From: Jones, Janet <Janet.Jones@enwl.co.uk>
Sent: 12 February 2015 13:05
To: planning
Subject: Your Reference 3/2014/0592 (Contact Colin Sharpe) Our Reference PA1868

The Moorcock Inn, Slaidburn Road, Waddington

4512-10 B

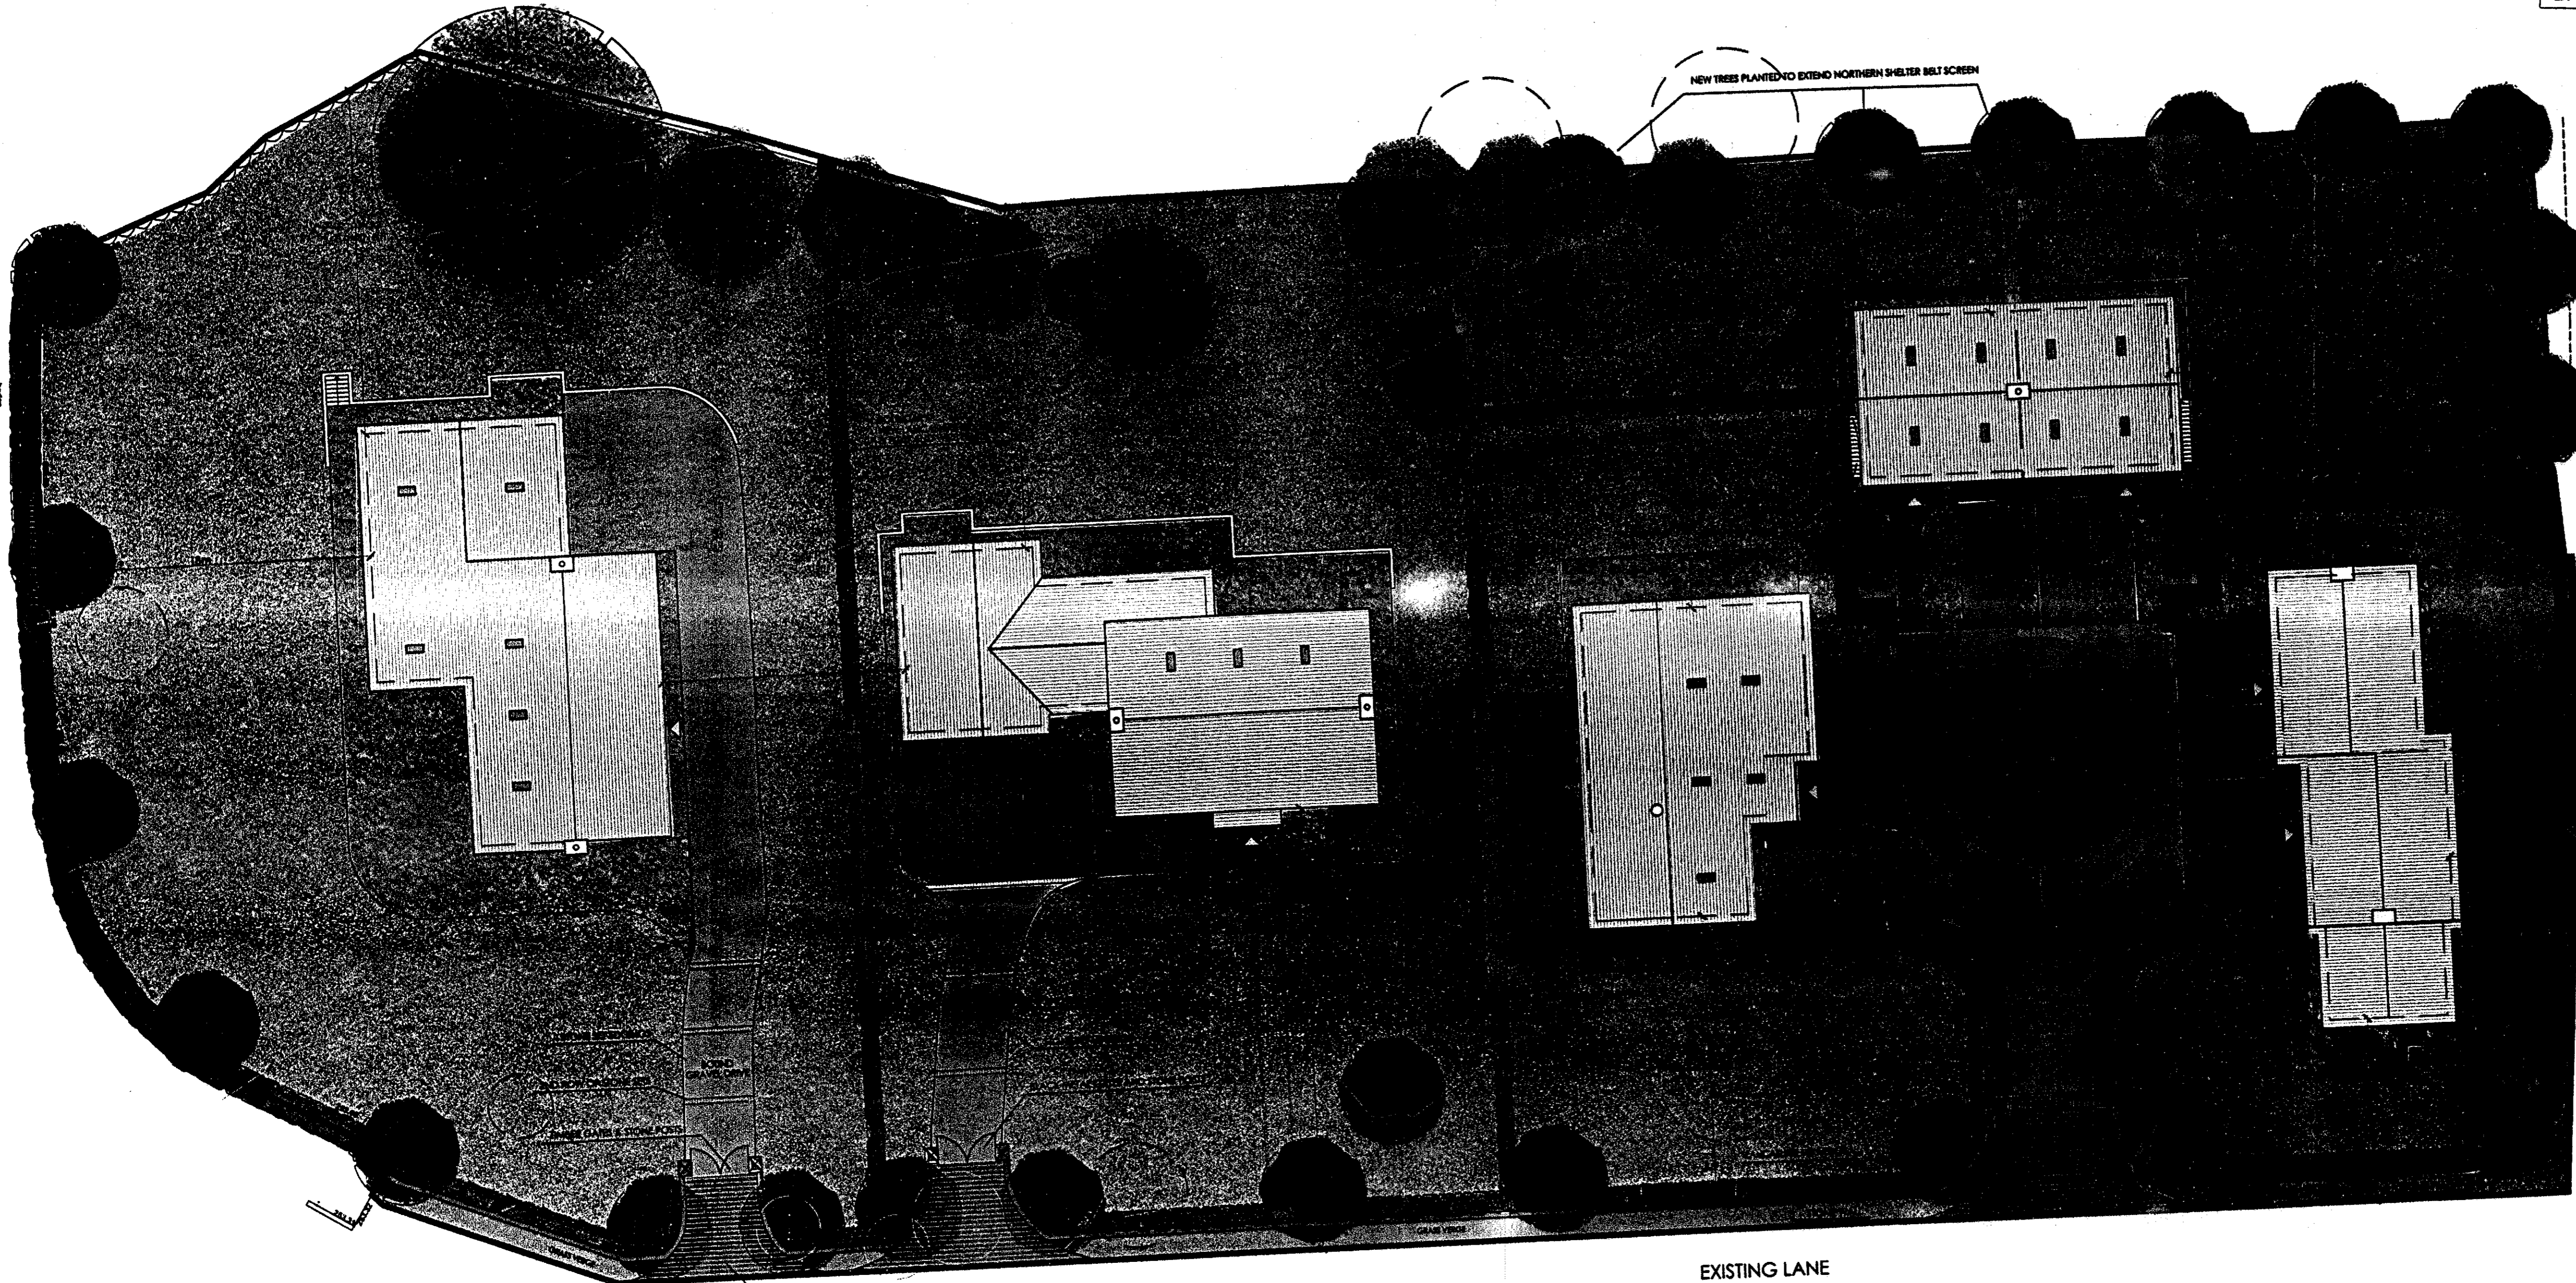
- The Moorcock distribution substation is located within an enclosure adjoining The Moorcock Inn and therefore any demolition works will require consultation with Electricity North West.
- It is noted that the proposed site plans include provision for the substation, however, consultation with Electricity North West will still be required to ensure adequate provision is provided.
- There are also Low Voltage cables emanating from the substation into the site, which will need to be made safe.
